Subject: Coastal quarter bray

I wish to submit an Observation regarding Shankill Property Investments Ltd.'s Strategic Housing Development application to build their 'Coastal Quarter' on part of the former Bray Golf Club lands at Ravenswell, Bray, Co. Wicklow - Case Ref. TA06D.314686.

Purpose	PLANNING
Title	ROAD LAYOUT - SHEET 2 OF 2
Original Scale	1:500 at A1
Design/Drawn	AK
Checked	CF
Authorized	KB
Date	19.08.22
Date	19.08.22
Date	19.08.22
Status	P
Drawing Number	5214419-ATK-01-ZZ-DR-CE-0104
Rev	P01

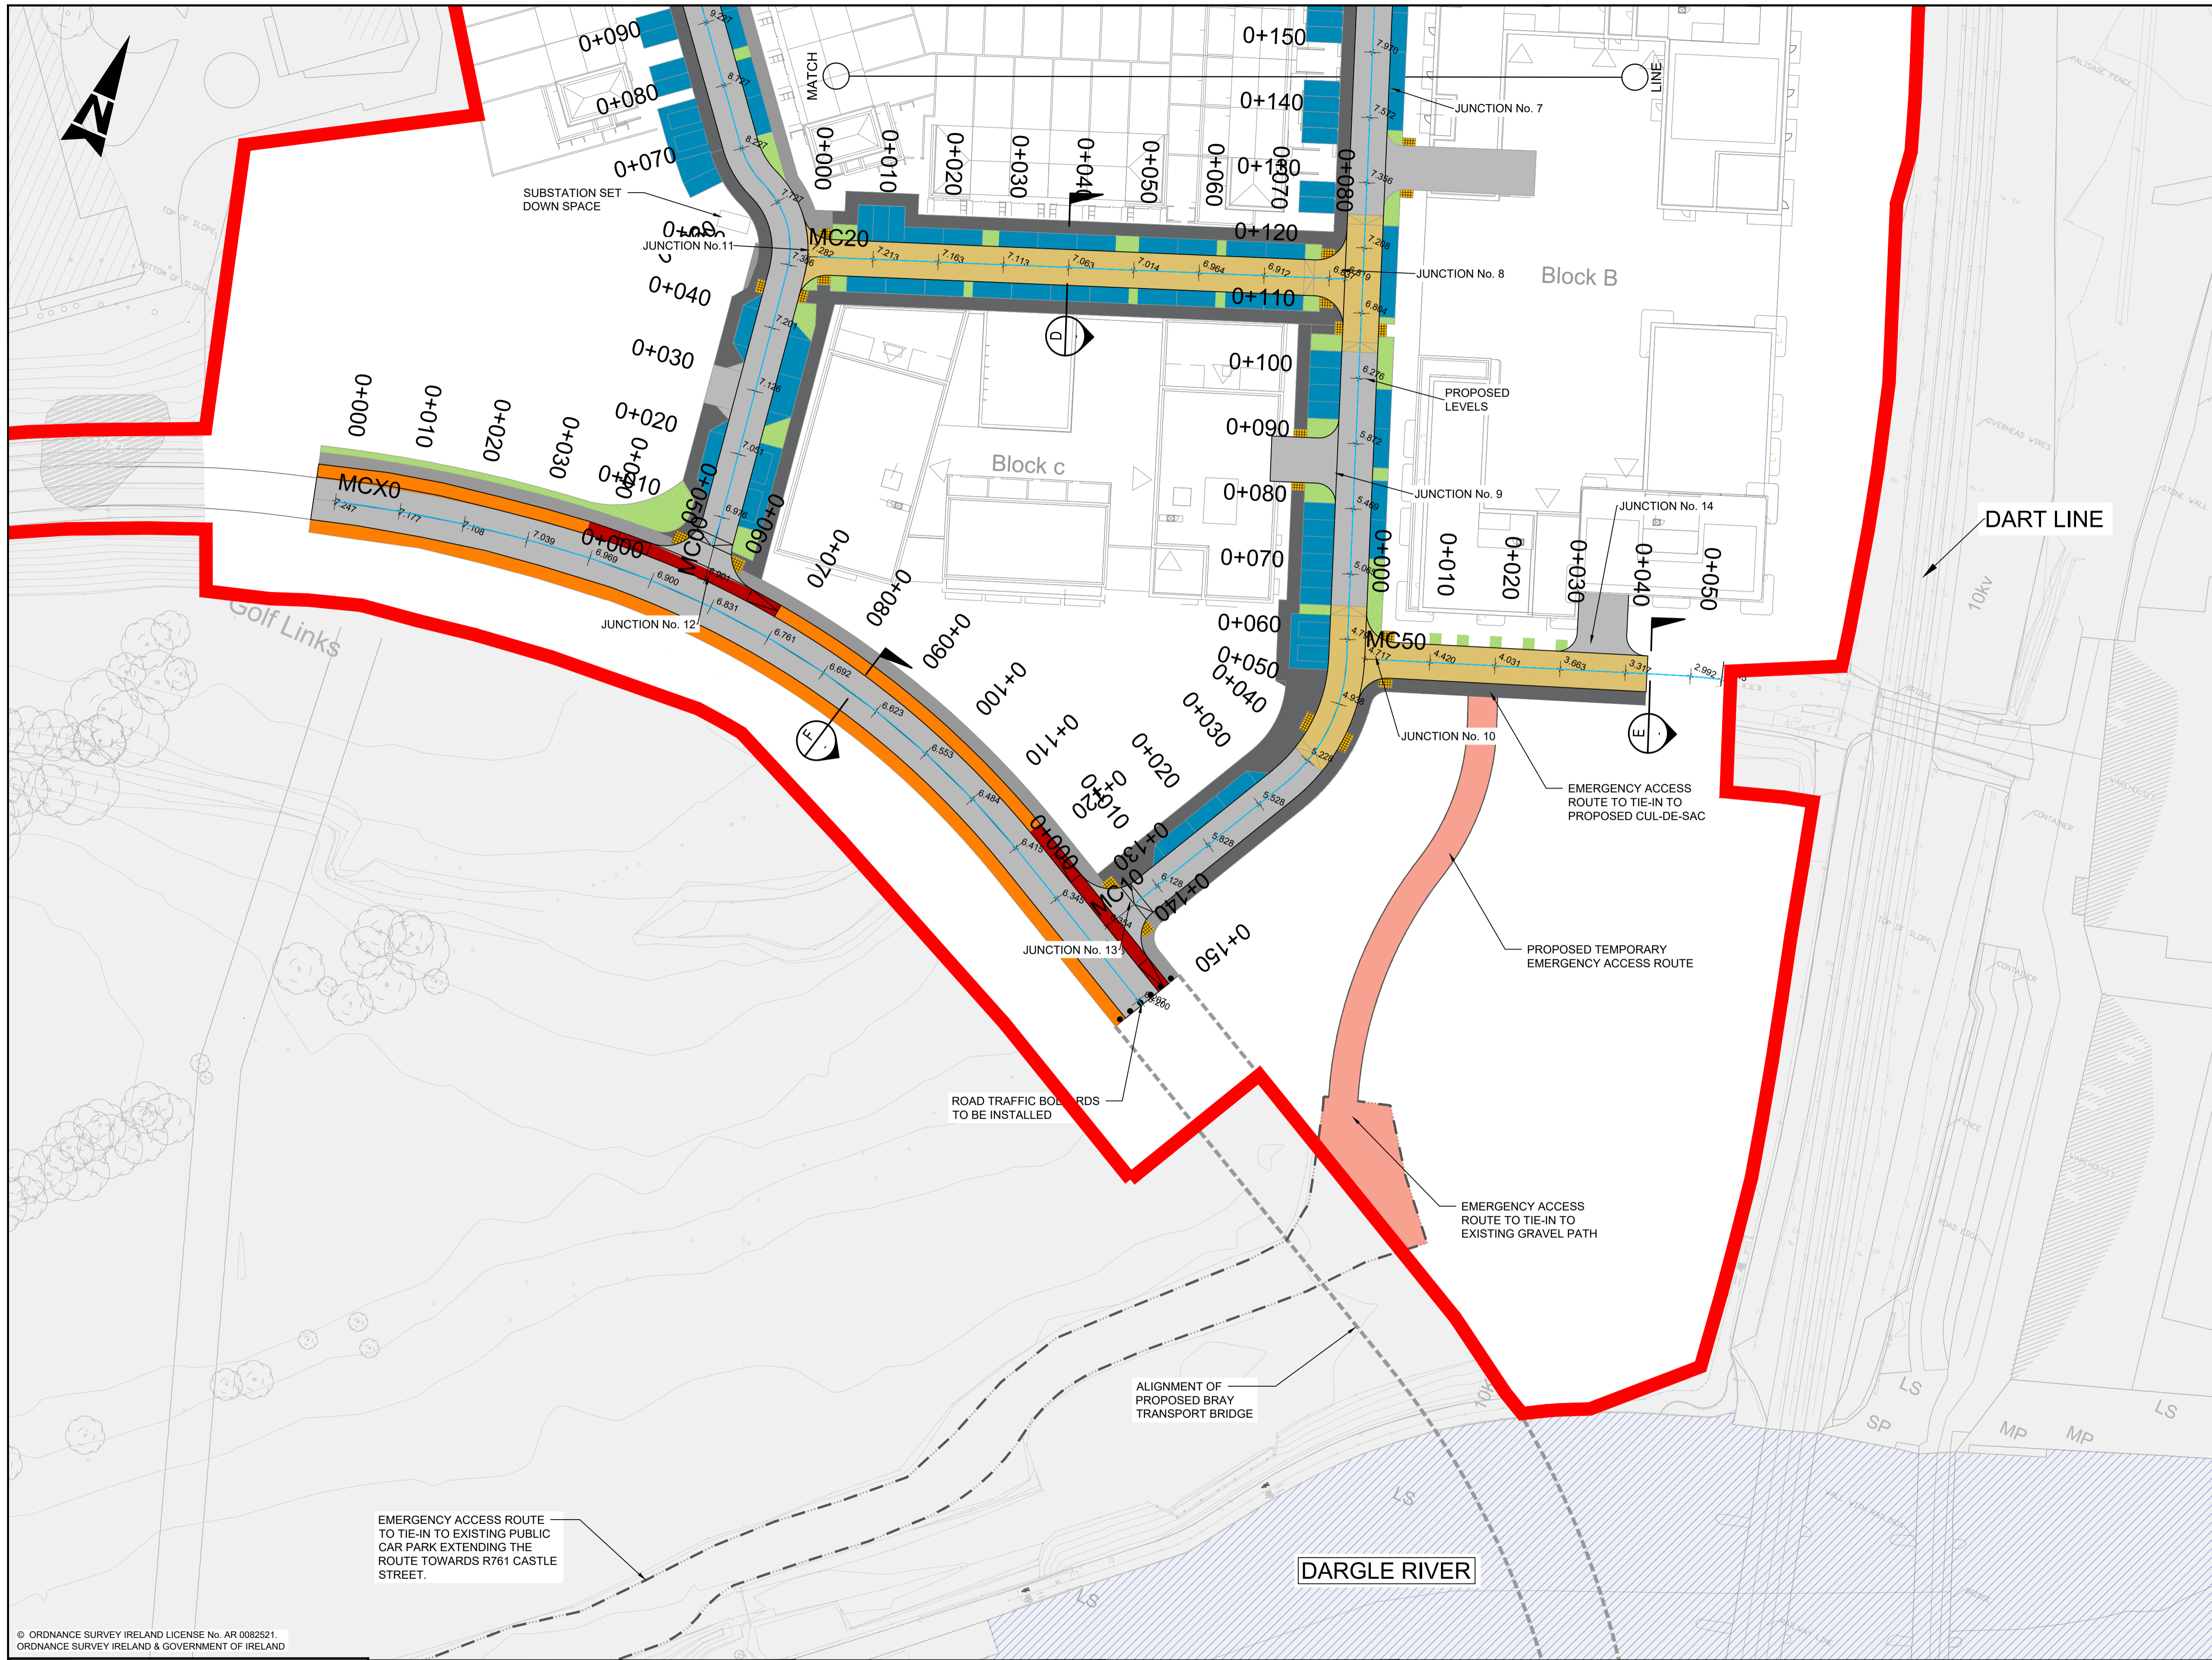
The southern part of Shankill Investments' application is built around a proposed access road (to a proposed public transport suspension bridge) which is the subject of a Judicial Review at present. Wicklow County Council submitted a Part 8 proposal (Ref. PRR 21/869) for this bridge and access road, maintaining that it would have no effect on the environment, and so an EIS would not be required. Surprisingly, BordPleanála's Inspector agreed with that assessment, despite the fact that Wicklow County Council are maintaining in their Part 8 proposal that the lowland of the old Bray Golf Club lands is a Flood Zone C, while Bray's LAP 2018 Flood Risk Assessment assesses that land as Flood Zones A and B – another direct contradiction in our local authority's flood risk

Shankill Investments claim that their application is 'stand-alone', yet their drawings, their graphics, and their text give the lie to this claim. In particular, their proposal on page 77 (graphic on page 78 at Fig. 18) of their Flood Risk

Assessment shows an intention to actually build up the level of the ground at the southern end of the site against the side of the proposed access road, which is proposed to be built on an embankment:

"In order to enable a sustainable development of the site and **to reduce the risk of flood inundation to the site it is proposed to raise ground levels within the southern area of the site**. It is also proposed to include a proposed road along the southern boundary within the model."

This a) simply assumes the access road will go ahead, with some contempt for the judicial process surrounding it; and b) shows no regard for the danger building up the ground level across the floodplain might cause for a very vulnerable community living upriver.
